Recommendation Report for Planning Permission

REF NO: M/43/15/PL

LOCATION: 6 Alleyne Way
Elmer
Middleton-on-Sea

PROPOSAL: Demolition of existing bungalow, detached garage & greenhouse & erection of 1 No dwelling, garage & garden shed (resubmission following M/24/14/PL).

**Replacement House
6 Alleyne Way
Elmer Sands
Middleton PO22 6JZ
Block plan**

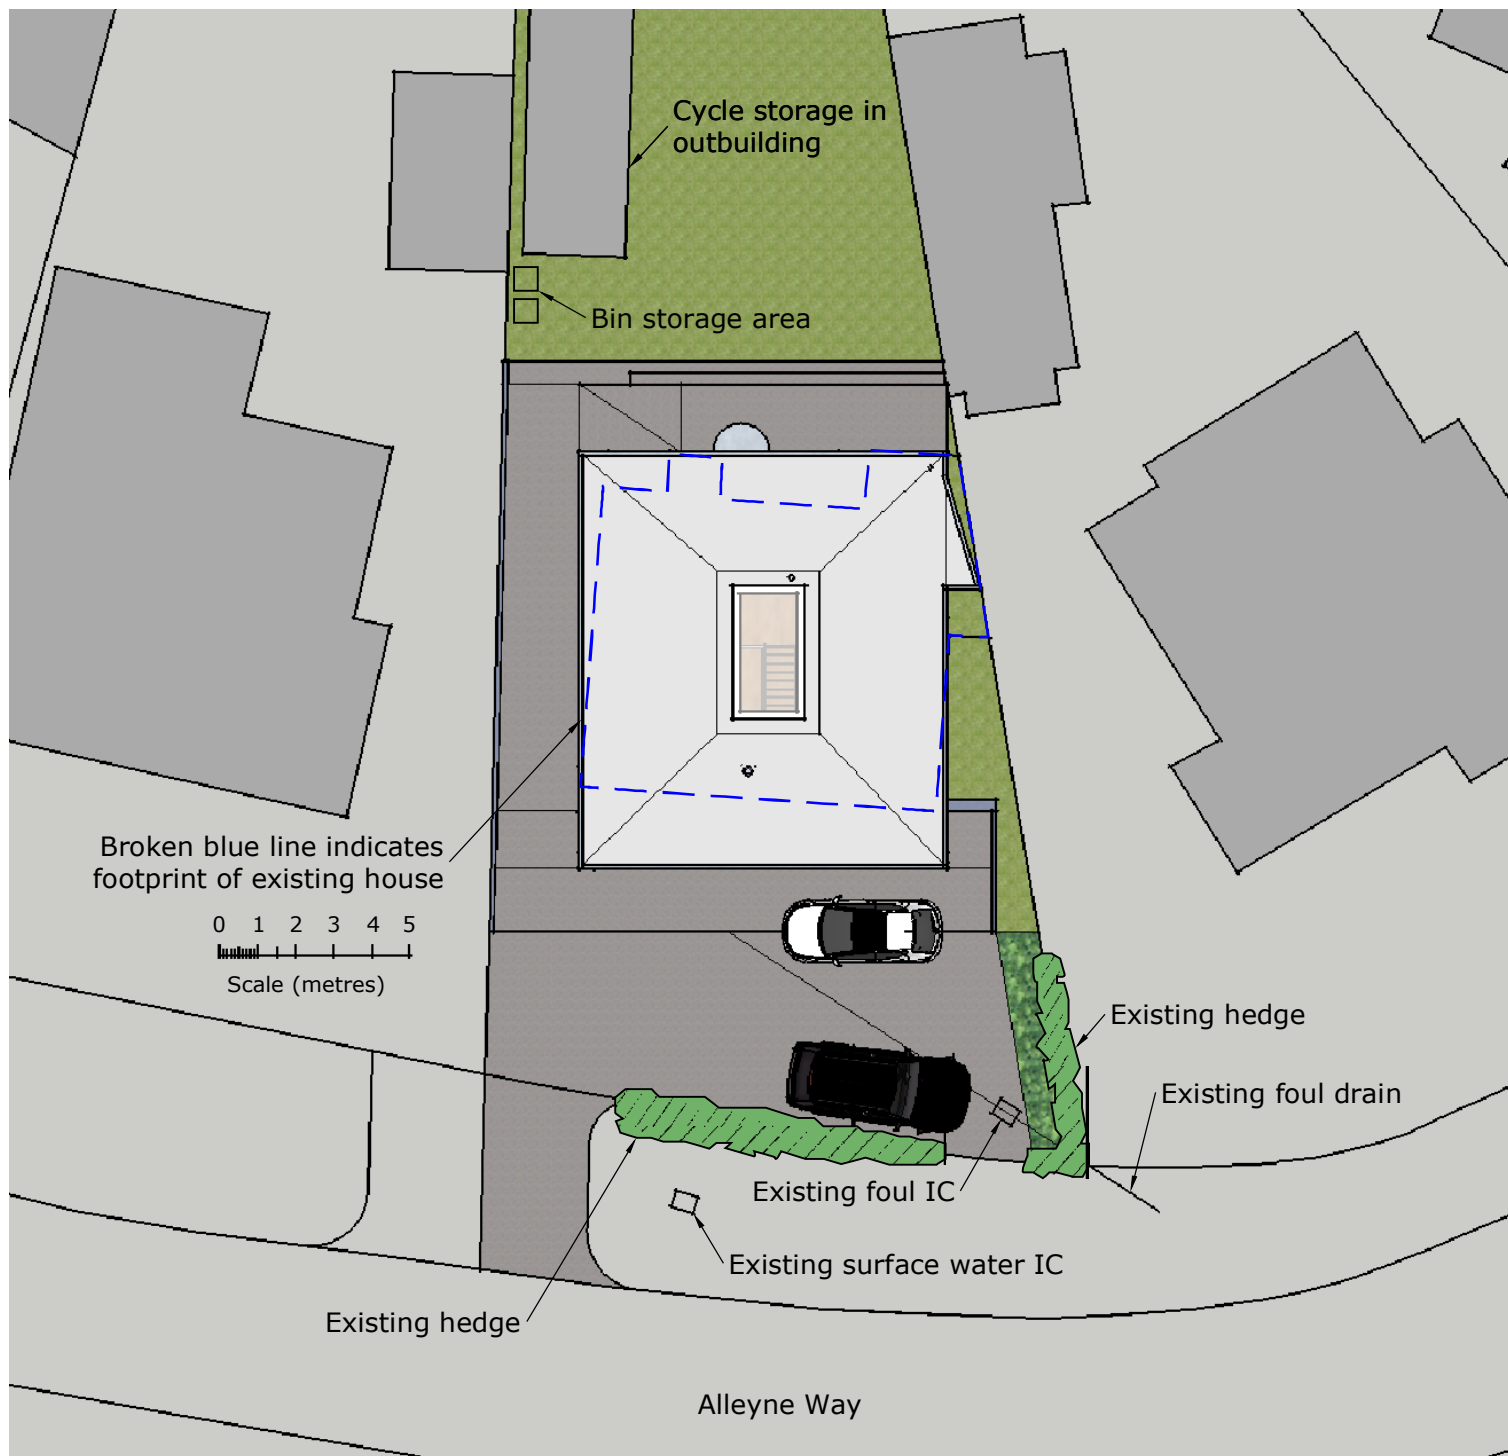
This application follows an earlier refused application for a replacement dwelling which was dismissed on appeal (M/43/15/PL). This submitted application is similar in design and appearance to the appeal proposal. The only difference is that the width of the dwelling has been reduced by 0.8m to provide a greater gap to the western boundary with 4 Alleyne Way.

Policy GEN7 of Arun District Local Plan states planning permission will only be granted for schemes displaying high quality design and layout. The details submitted do not respect the existing character of the area. The properties adjacent to the site have gaps to at least one side boundary of between 3 and 5 metres on the site frontage providing vehicular access to rear garages. This results in a spacious pattern to the existing development and the perception of space between detached properties. The proposal would provide only 1.7m to one side boundary, reducing to 0.3m to the rear and 2m to the other which would compromise this existing pattern of development. The cramped appearance that results is worsened by the height of the proposed dwelling in relation to the side boundaries. Most development in the locality comprises detached bungalows/chalets with low eaves and ridge lines. The dwelling would have a height of 6 metres, within 2 metre from the boundary, which increases the visual presence and obtrusive nature of the building, contributing to an increased perception of overdevelopment of the site. It is accepted that the footprint of the dwelling has not increased significantly, but the additional development close to the boundary and the increased height render this limited increase unacceptable. The reduction in width of the proposal of 0.8m has not satisfactorily addressed previous concerns.

Replacement House
6 Alleyne Way
Elmer Sands
Middleton PO22 6JZ
North & South Elevations

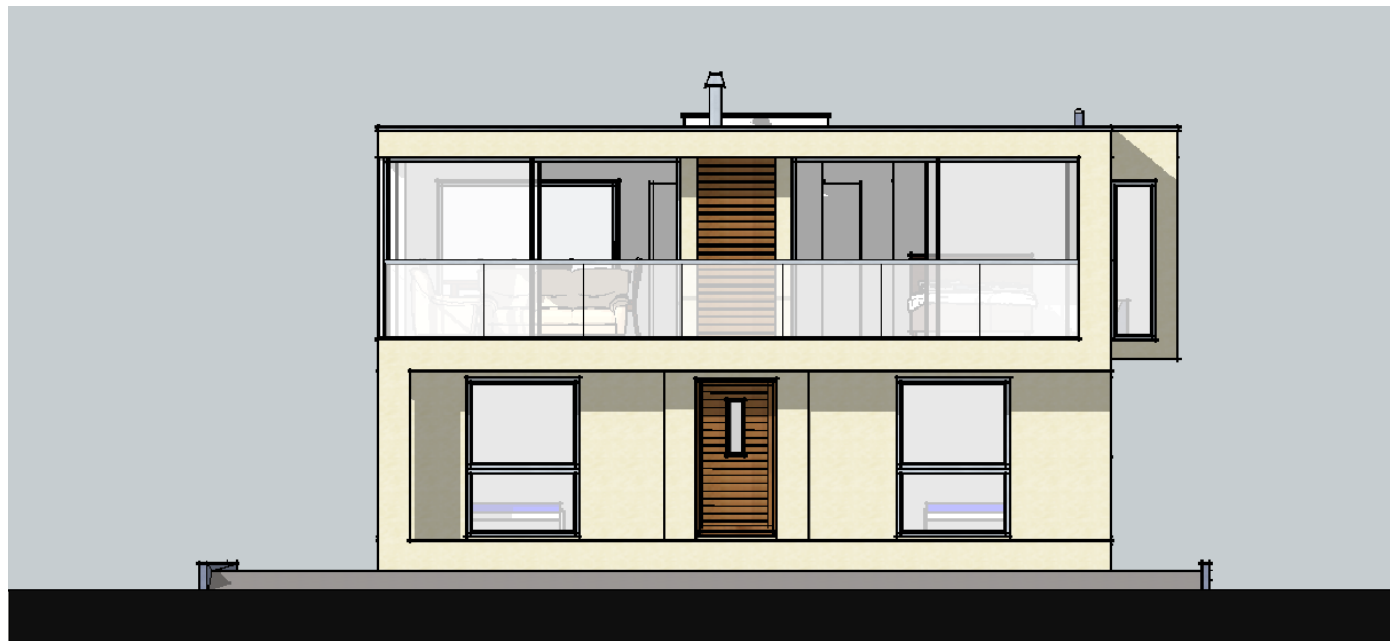
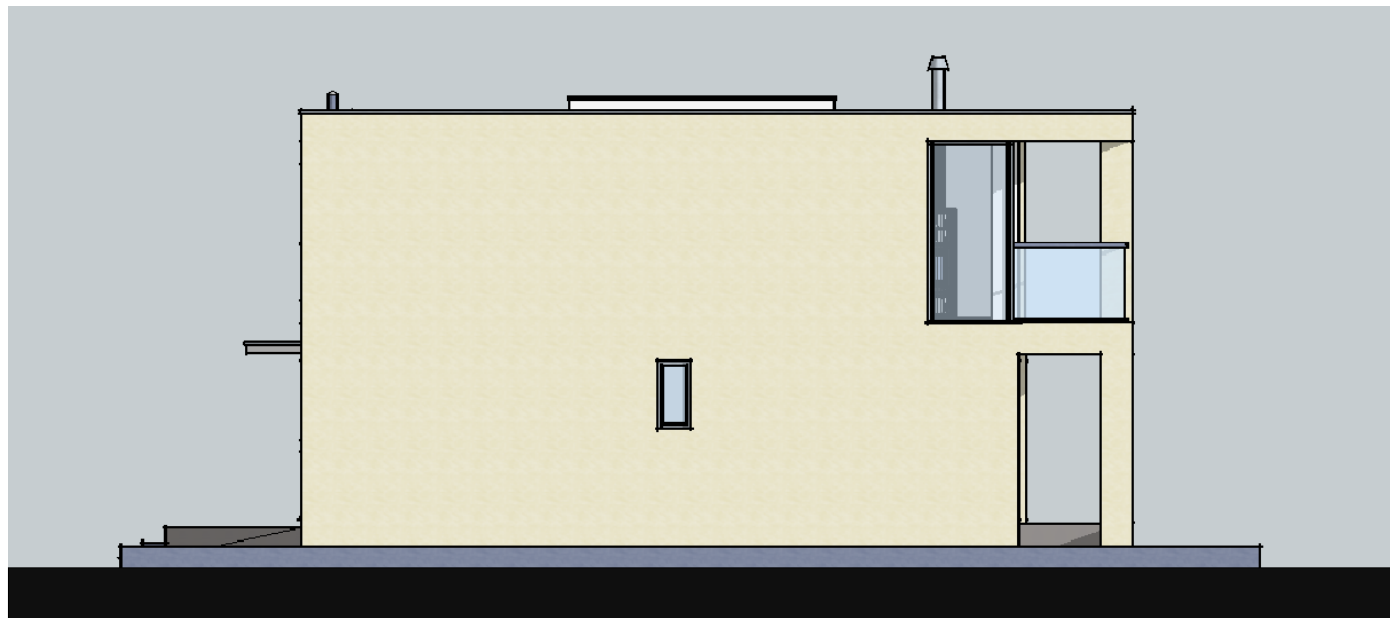
The appeal Inspector stated the buildings in the area are essentially small in scale the appeal property has a particularly low roof profile and is not prominent in the streetscene. The increase in height and bulk of the walls of the side elevations, in closer proximity to the boundaries than the existing dwelling would be highly visible from the road. The removal of the front boundary hedging would exacerbate this situation.

When the proposal is considered in combination with the flat roof design and bulk of the structure across most of the site this would draw the eye to the proposed scheme. The proposed dwelling has a very prominent appearance which would be overly dominant in relation to nos 4 and 8 in particular and would be significantly out of keeping with properties in this location. The proposal does not result in minor changes which would be capable of being absorbed in the street scene. The potential sustainable building techniques do not outweigh the harm identified.

This revised scheme has not reduced the overall height of the proposal which the inspector identified as an issue and it has not increased the distance to 8 Alleyne Way which was also specifically referred to. Accordingly the proposal remains prominent and obtrusive in the street scene.

1 Having regard to the width of the dwelling, its proximity to site boundaries and its height

the proposed dwelling would appear cramped and obtrusive in the street scene to the detriment of the visual amenities and character of the locality in conflict with policy GEN7 of the Arun District Local Plan and policies DSP1 and DDM1 of the Emerging Local Plan.
